Your Ref: OWQC25493
Our Ref: K/32/19/PL
Please ask for:
Mr Z Denton

Demolition of existing dwelling and erection of 1 x three storey dwelling with swimming pool and associated amenity space and parking
Little Deerswood Gorse Avenue Kingston Gorse

Thank you for your internet comments made on 22nd January 2020 which has been recorded as **'an objection'** with the comments as follows:

1703 SK121  
 Little Deerswood, Kingston Gorse  
 Ground Floor Plan  
 Scale 1:100

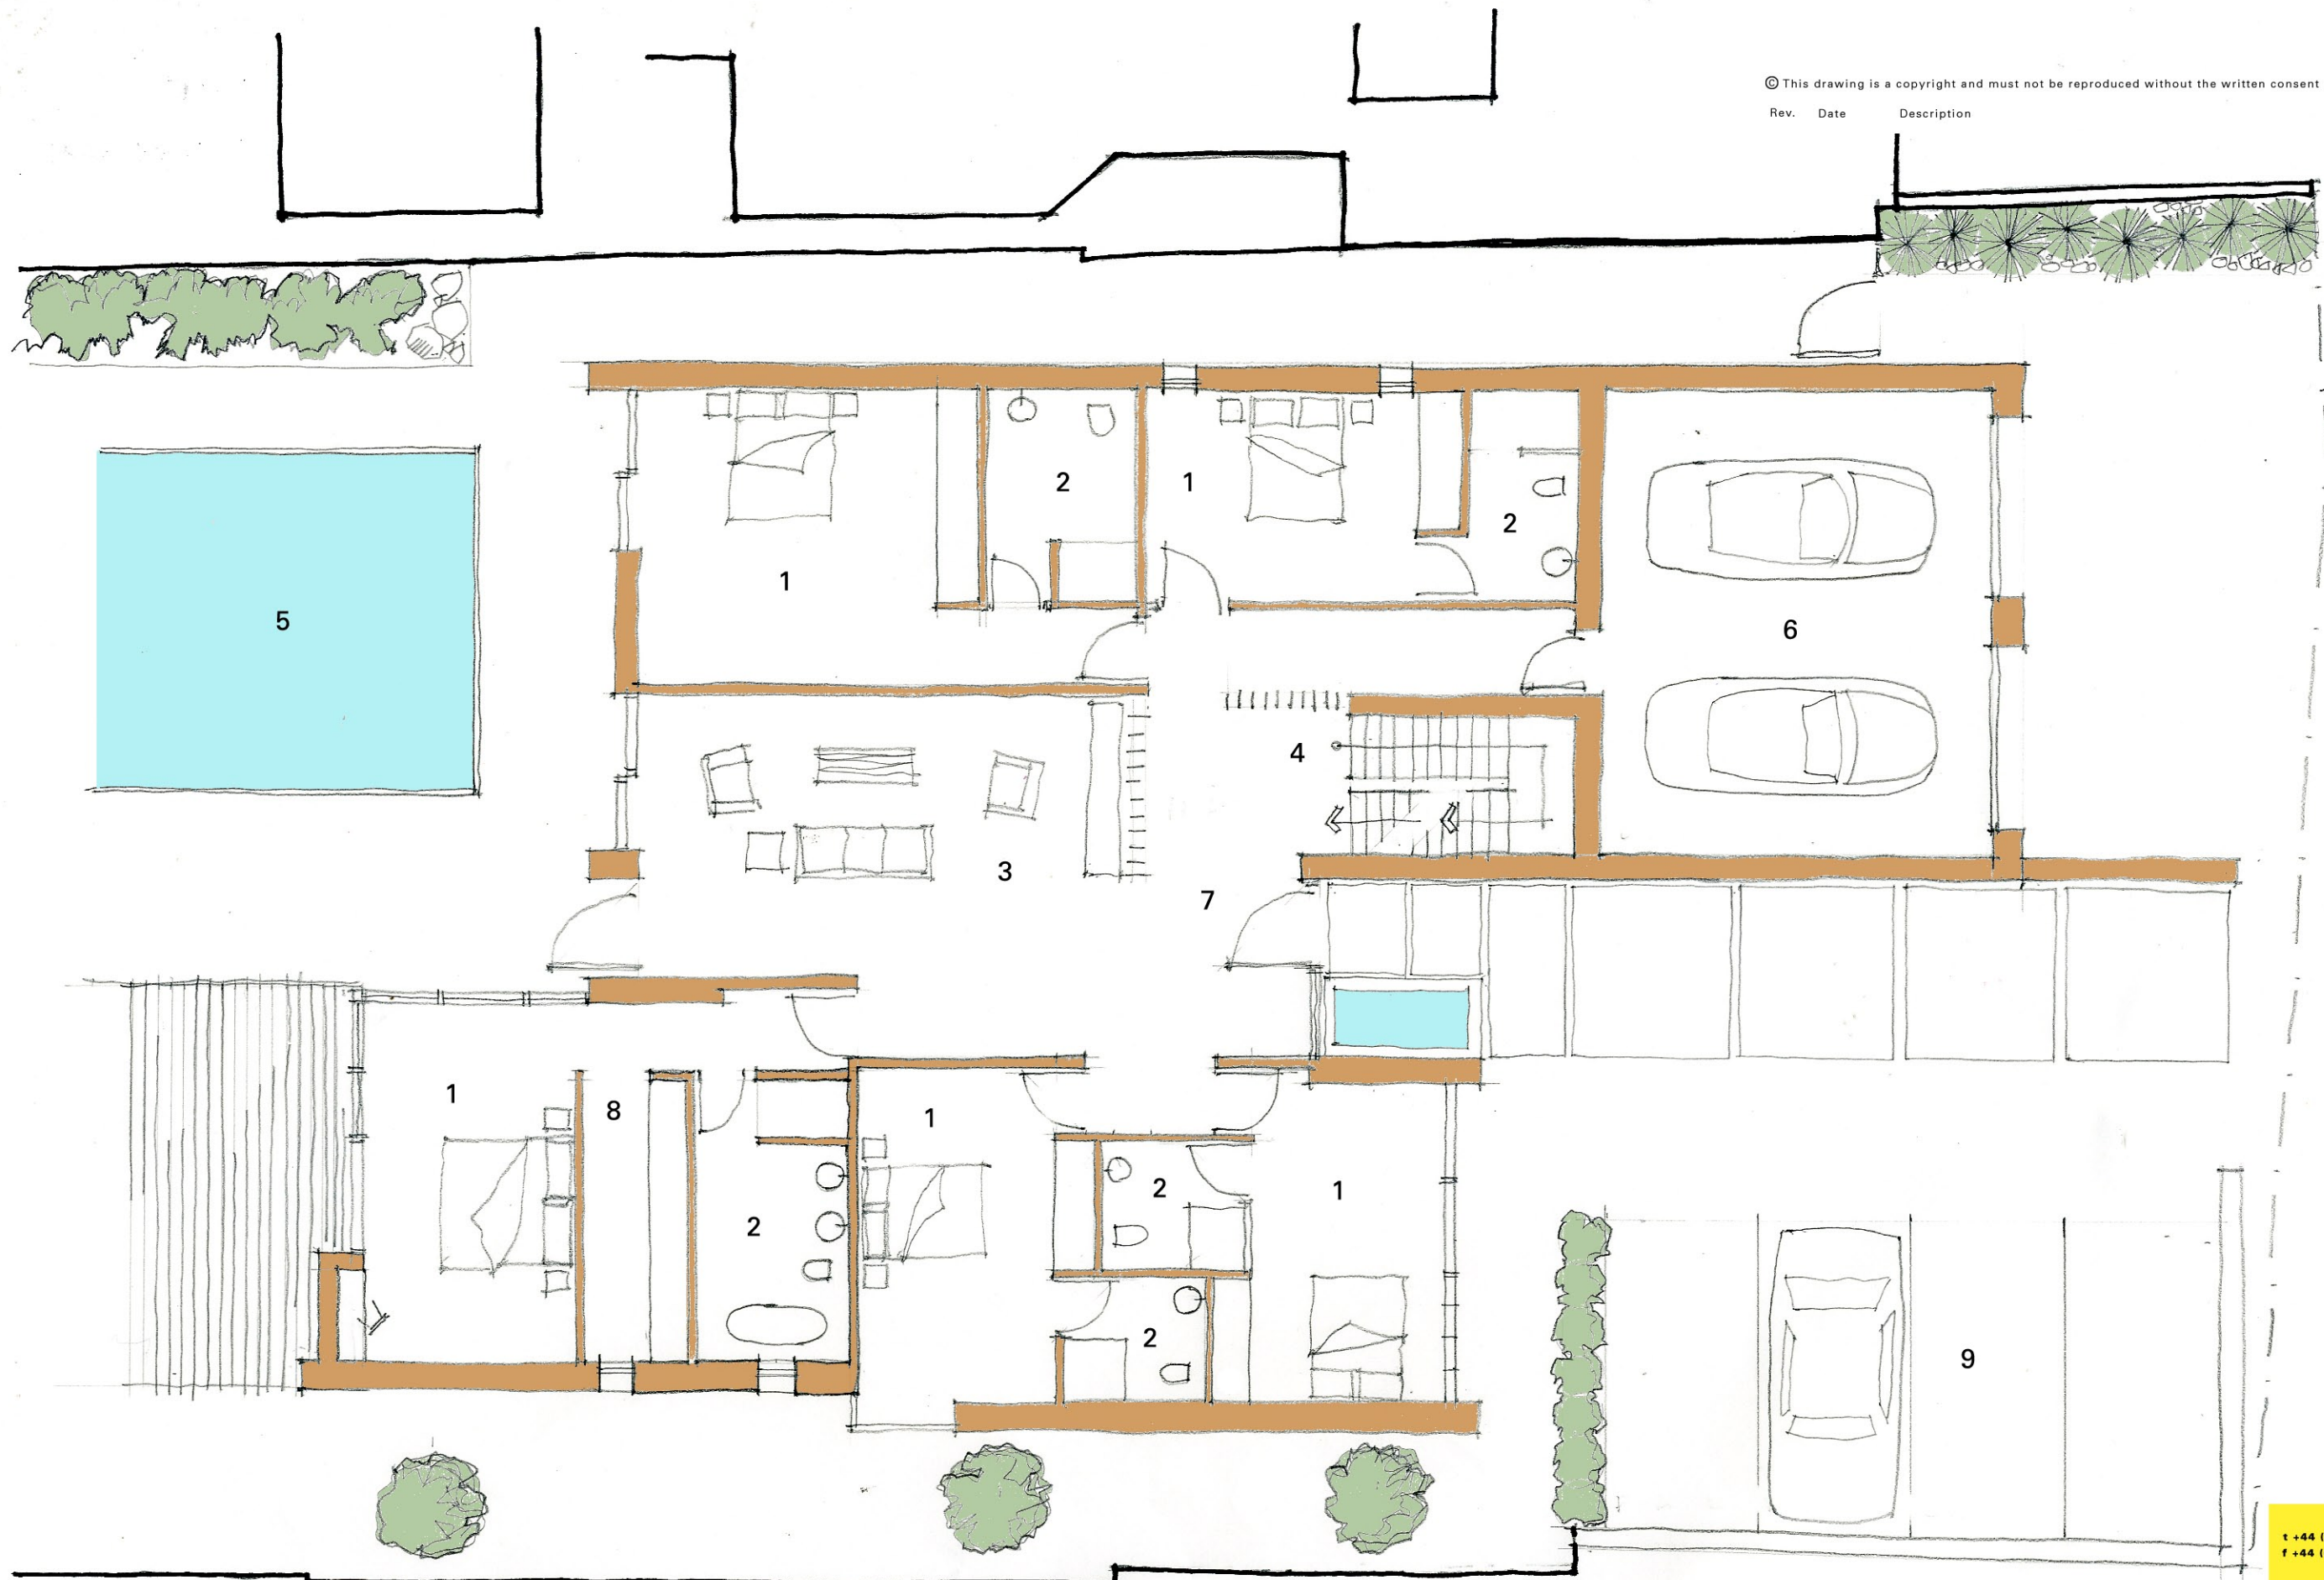
- 6. This is a large 5 bedroom property and Council is concerned that the parking provision is inadequate for residents of the proposed dwelling and visitor parking. There is no on-street parking allowed in the vicinity. There is no measurement of the section of driveway*

in front of the garage and within the curtilage of the property. Council considers that parking outside of the garage will overhang the crossover which is not within the curtilage of the property and this is not acceptable as it will affect road safety and the character of the street scene.

1703 SK126
 Little Deerswood, Kingston Gorse
 South Elevation
 Scale 1:100

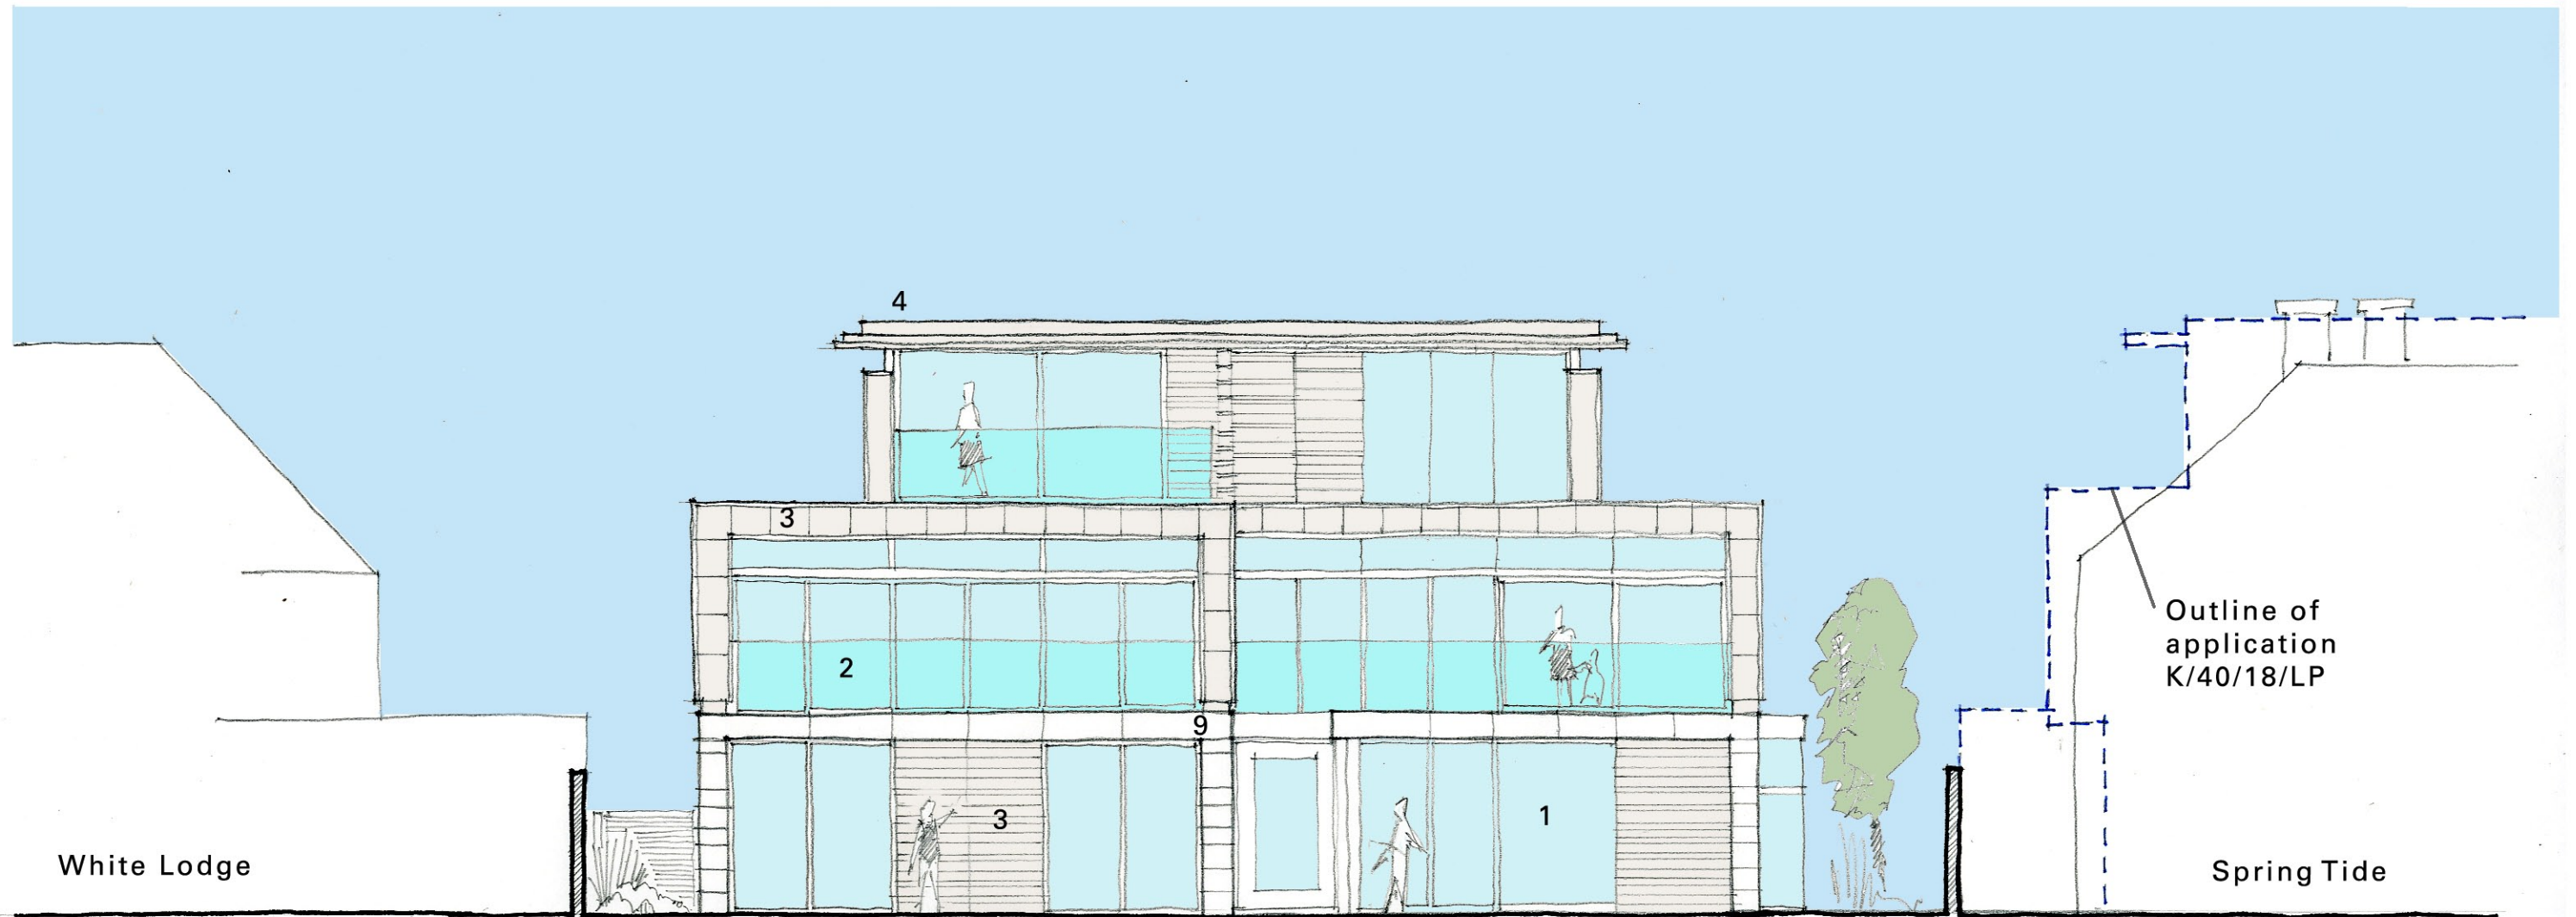
- 3. The site backs onto the greensward running along the edge of the beach, which is a popular coastal footpath and leisure route for residents and visitors. This effectively means the property has a frontage to both north and south. The proposed dwelling when viewed from the greensward is considerably forward of the building line of the neighbouring property to the west.*

1703 SK127
Little Deerswood, Kingston Gorse
West Elevation
Scale 1:100

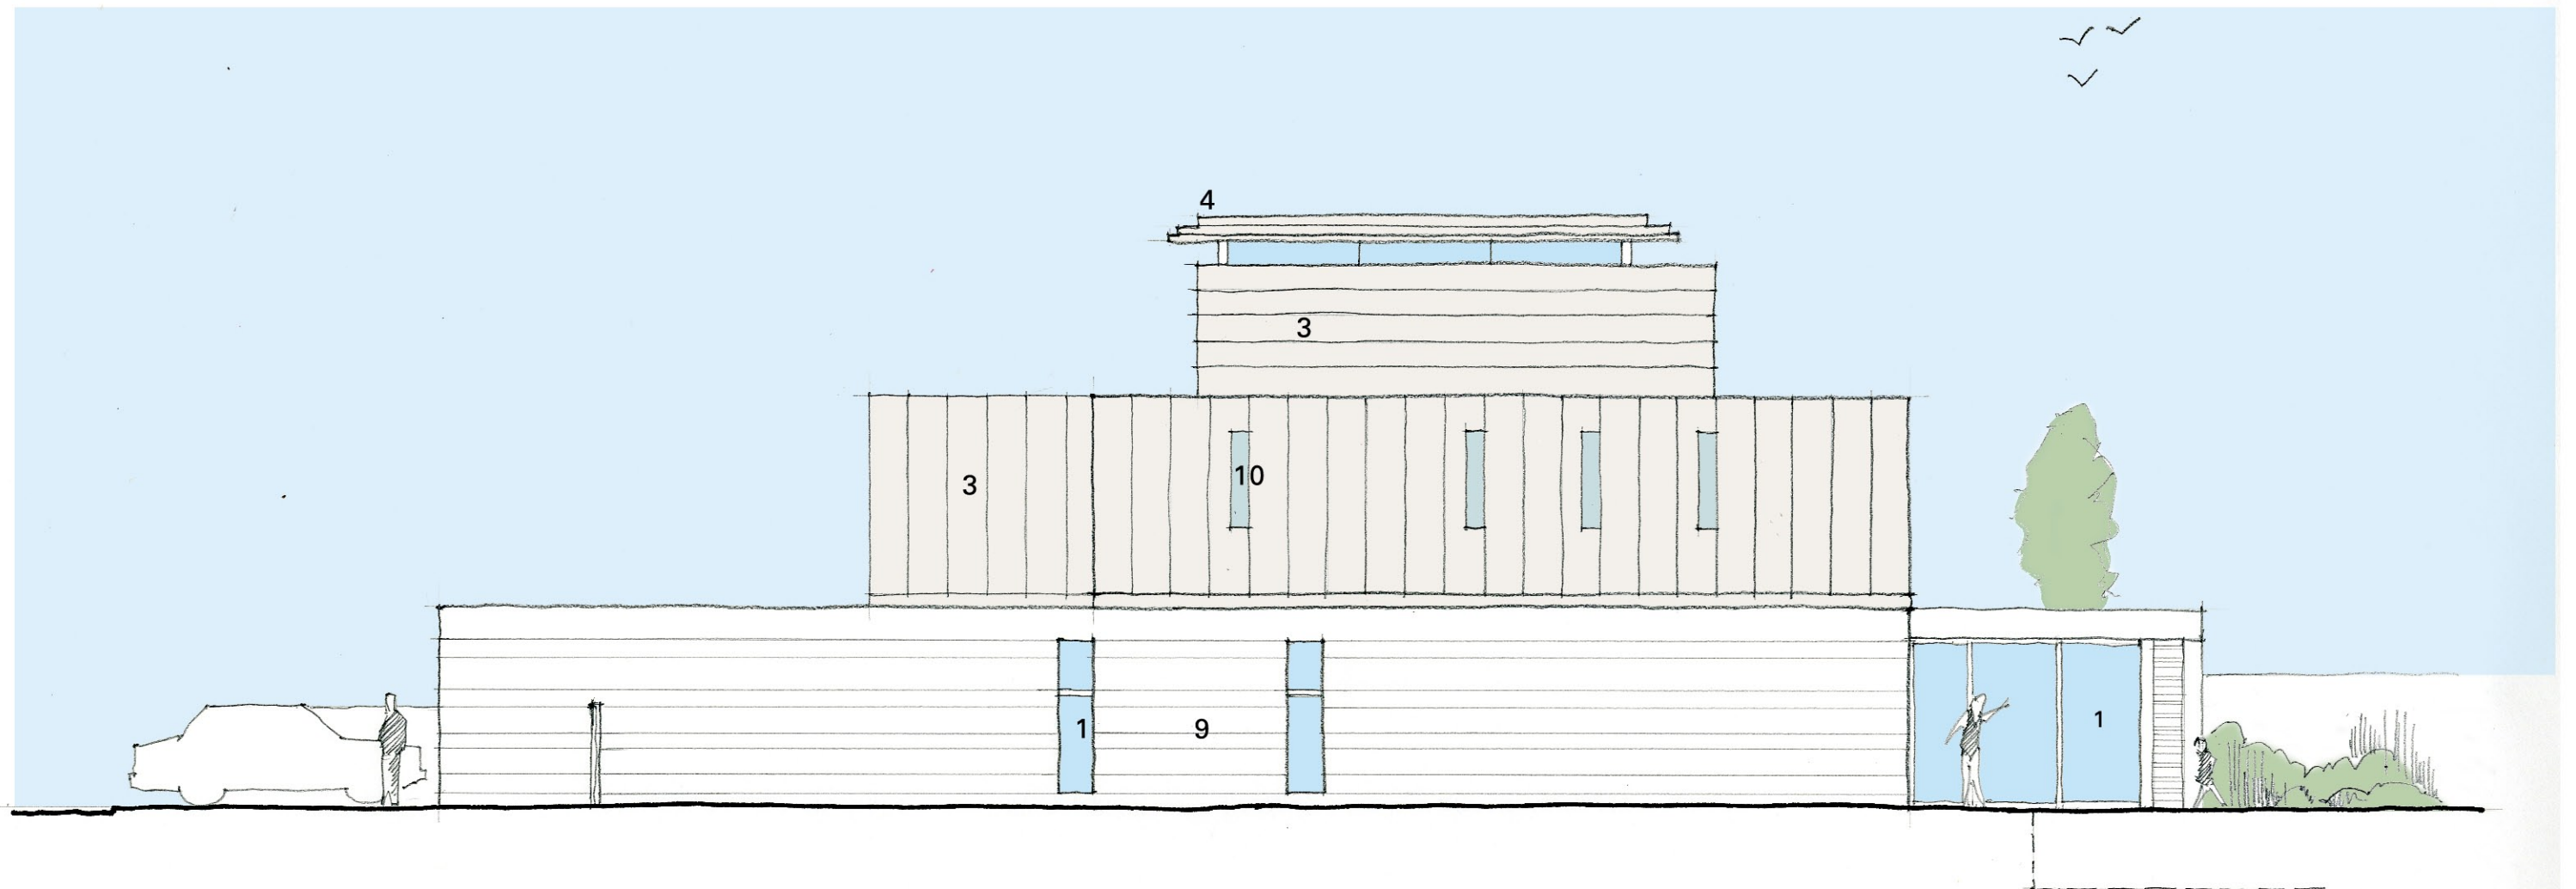
- 1. The proposed development is out of scale to the existing dwelling and by reason of its increase in scale, width, height, bulk and design will constitute overdevelopment of the site. This includes a rise in roof height and shape to create a 3-storey dwelling. The roof height is higher than the neighbouring property to the west and the building (garage) is further forward than the existing and neighbouring garage.*
